Dear Sirs, Re: Planning application Muller Pendle Mill No: 3/2022/0632

As a 3 story 70 bedroom care home is totally inappropriate for this site.

Existing Site Section A-A

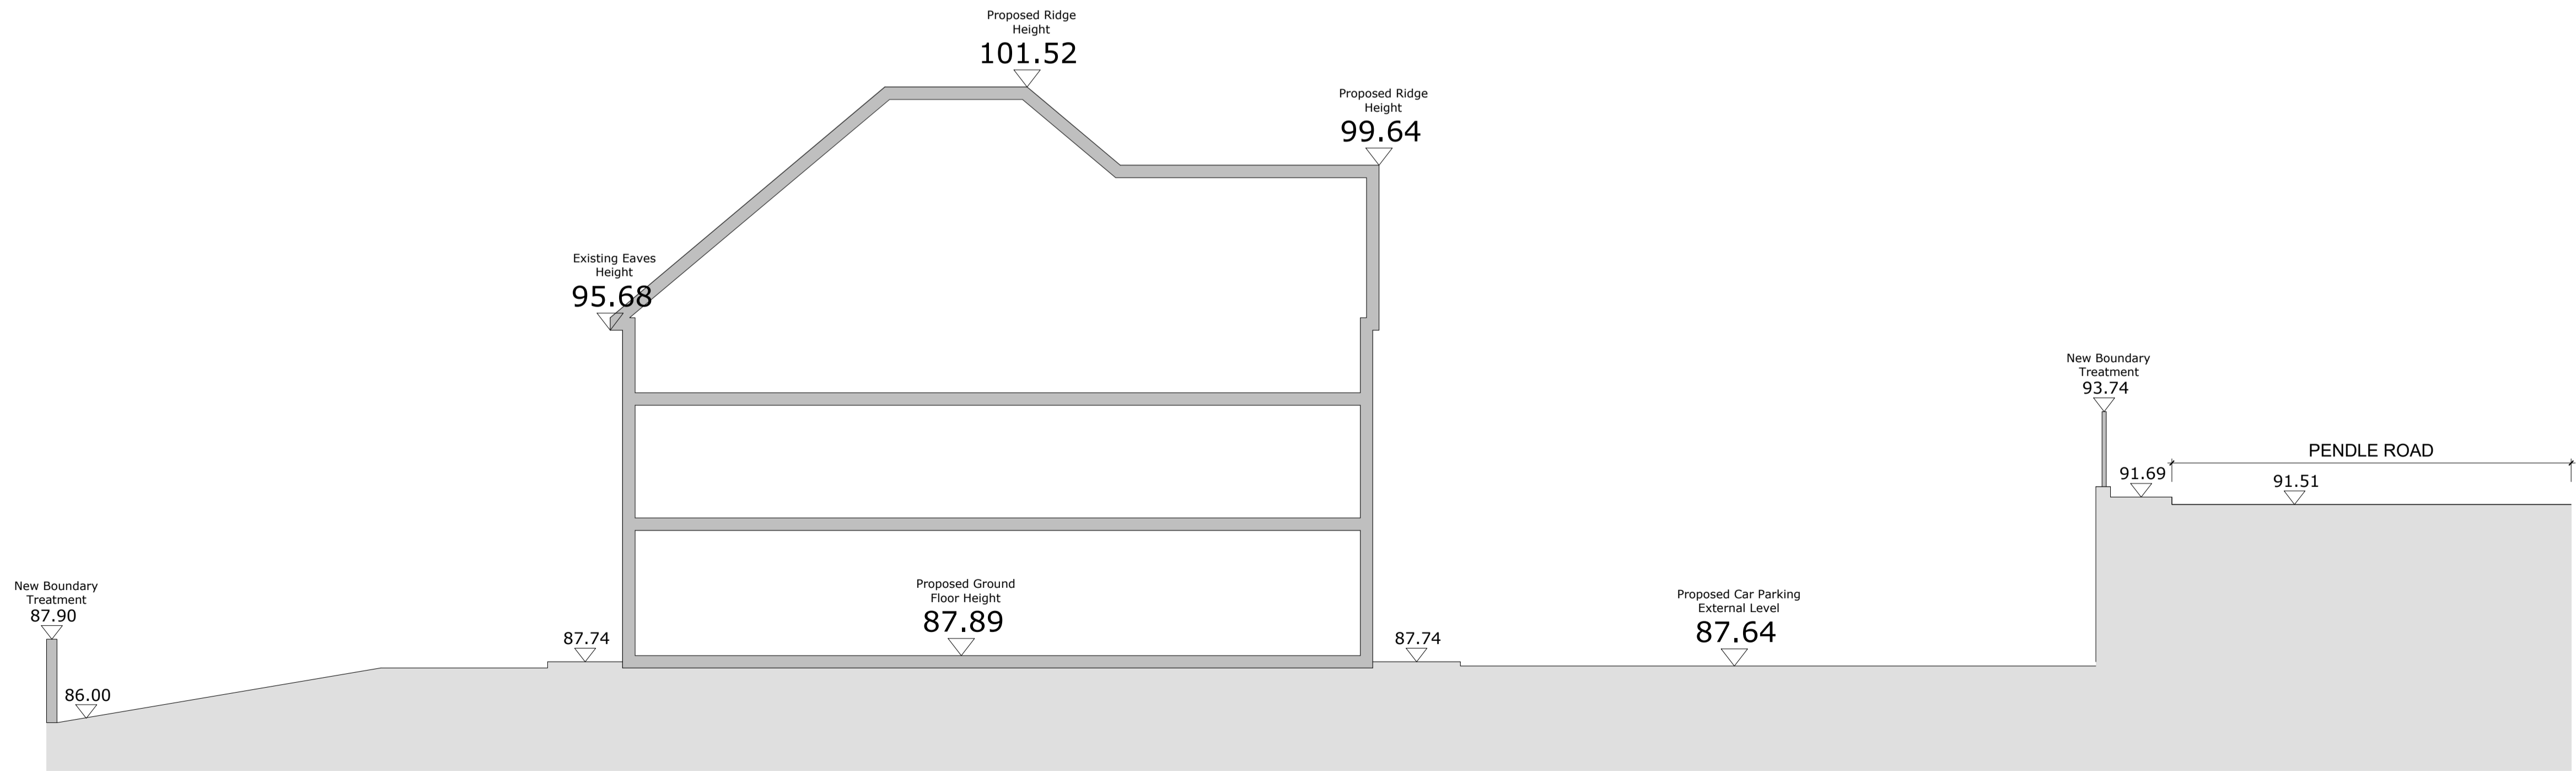
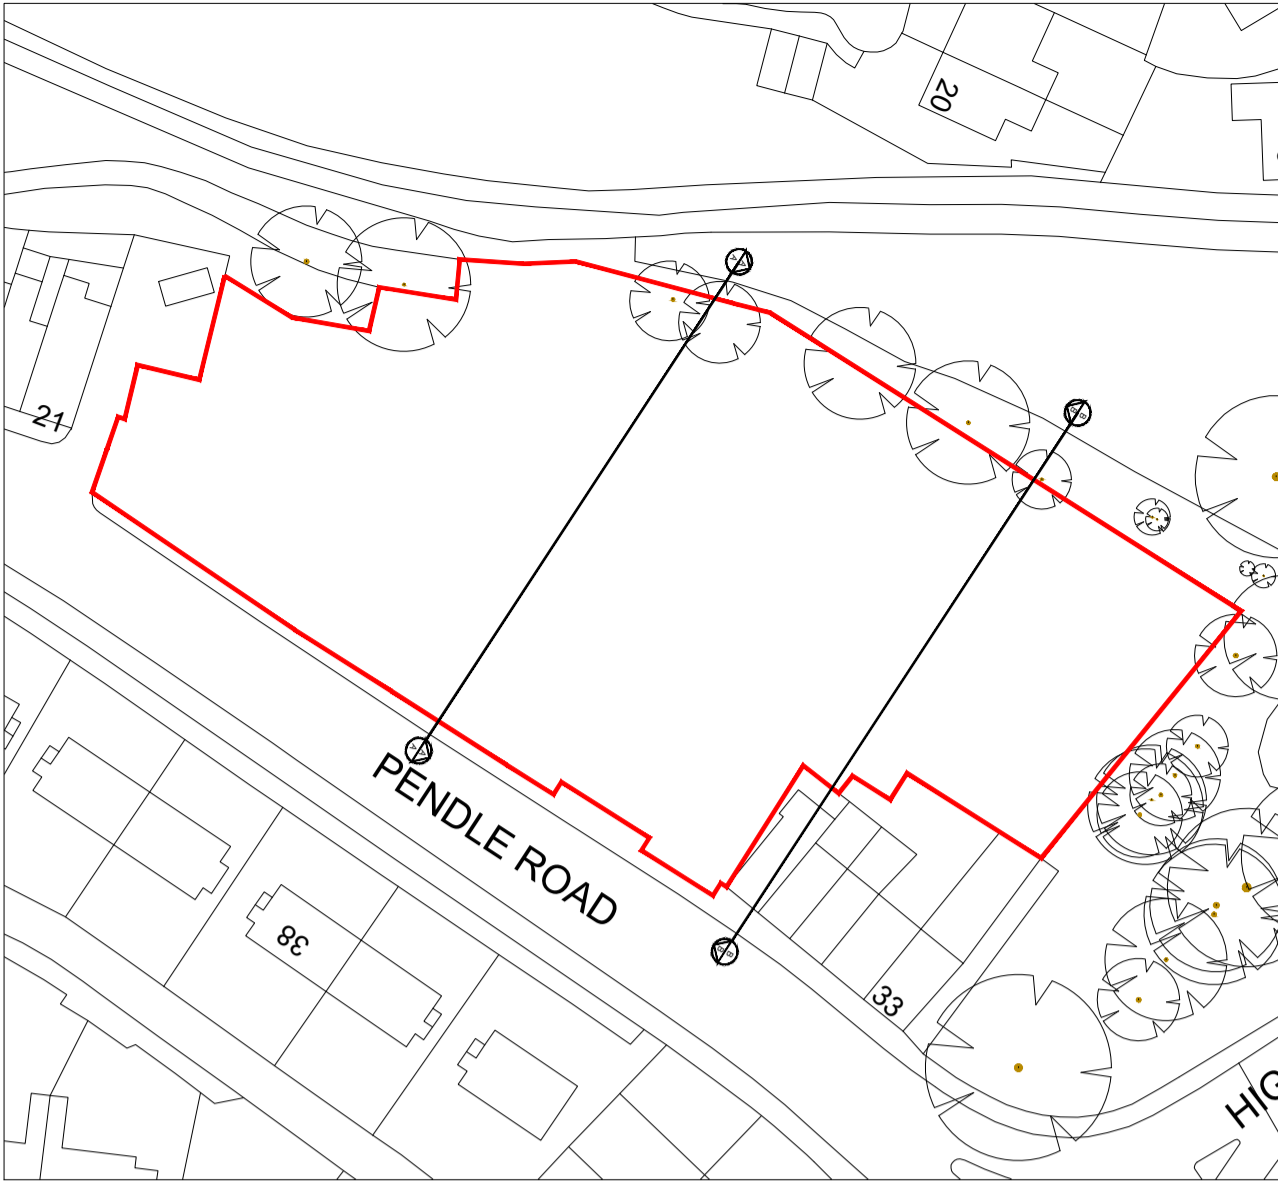
- (1) I have attached two of their plans, to indicate that they have included [REDACTED] in their plans, I have [REDACTED] I am very concerned that if the build up to [REDACTED] as indicated on their plan it will be 10ft below the foundations of [REDACTED] which to me it totally unacceptable.

Drawing Title
 Proposed Site Plan with Culvert and Trees

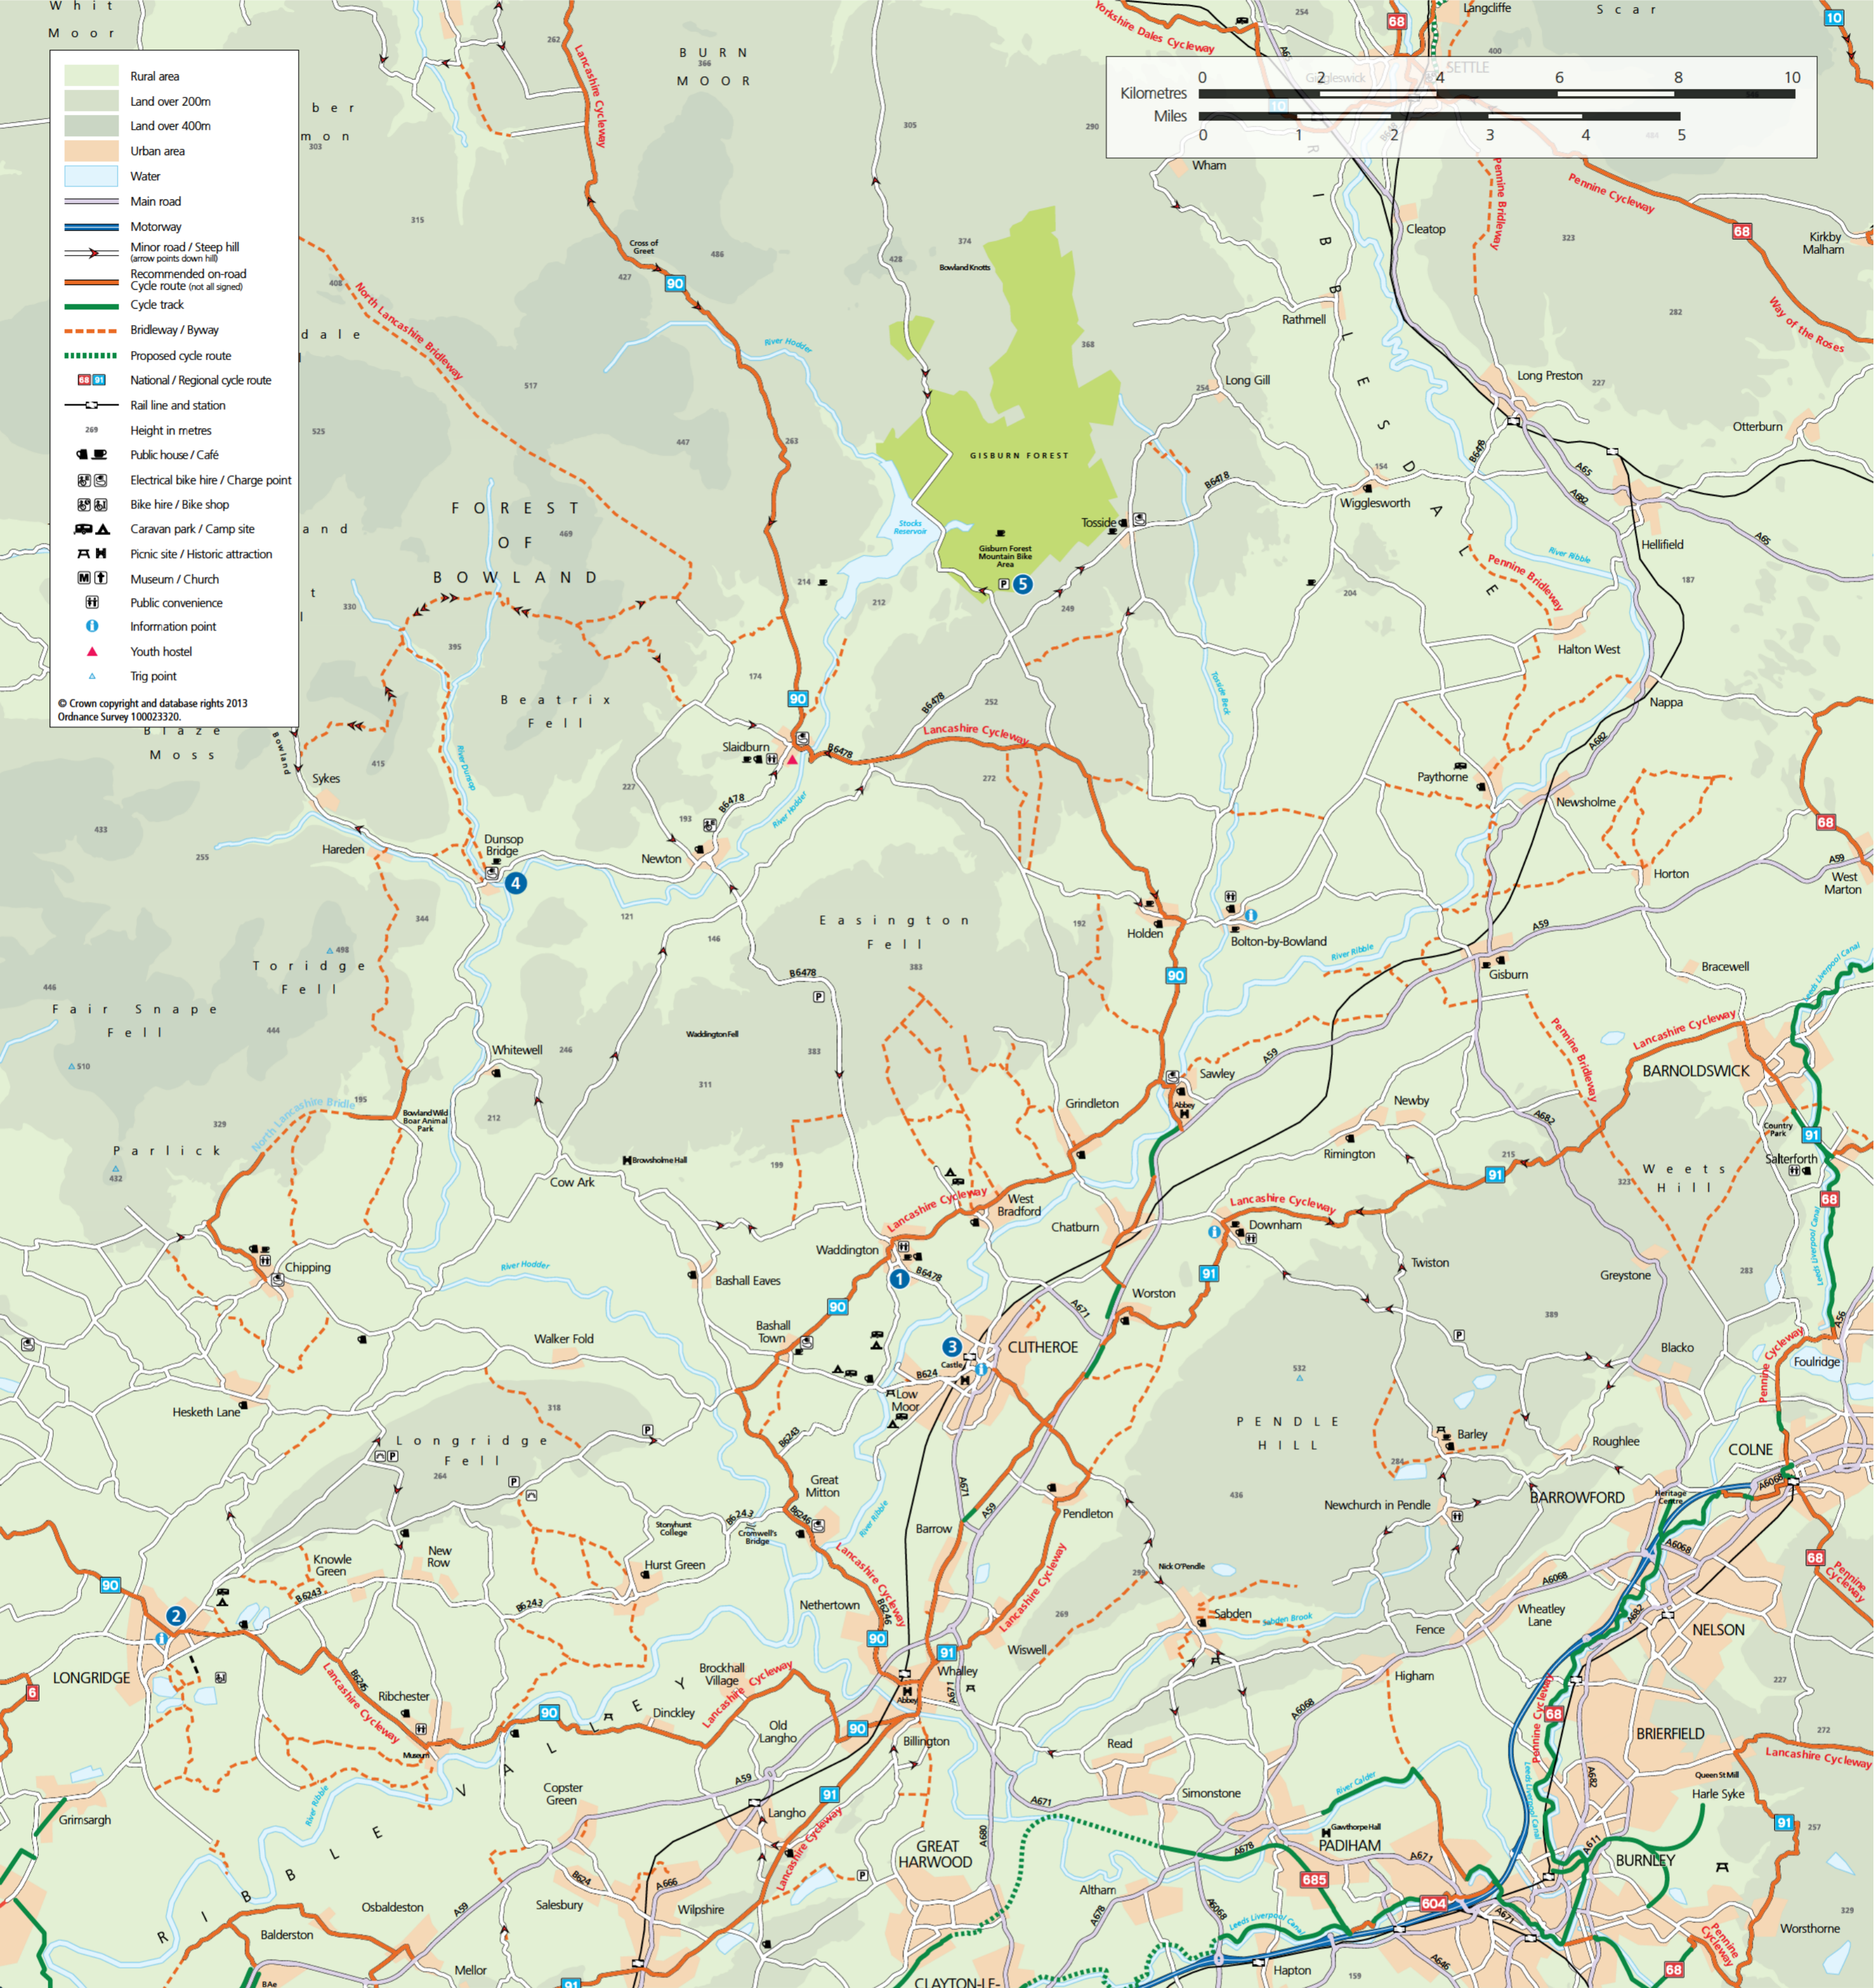
- (2) The new entrance from Pendle Road on to the site is again totally inappropriate for such a main road, traffic some days is back up from shawbridge to Goosebutts, when there is a football match on, they are parked all up pendle road.
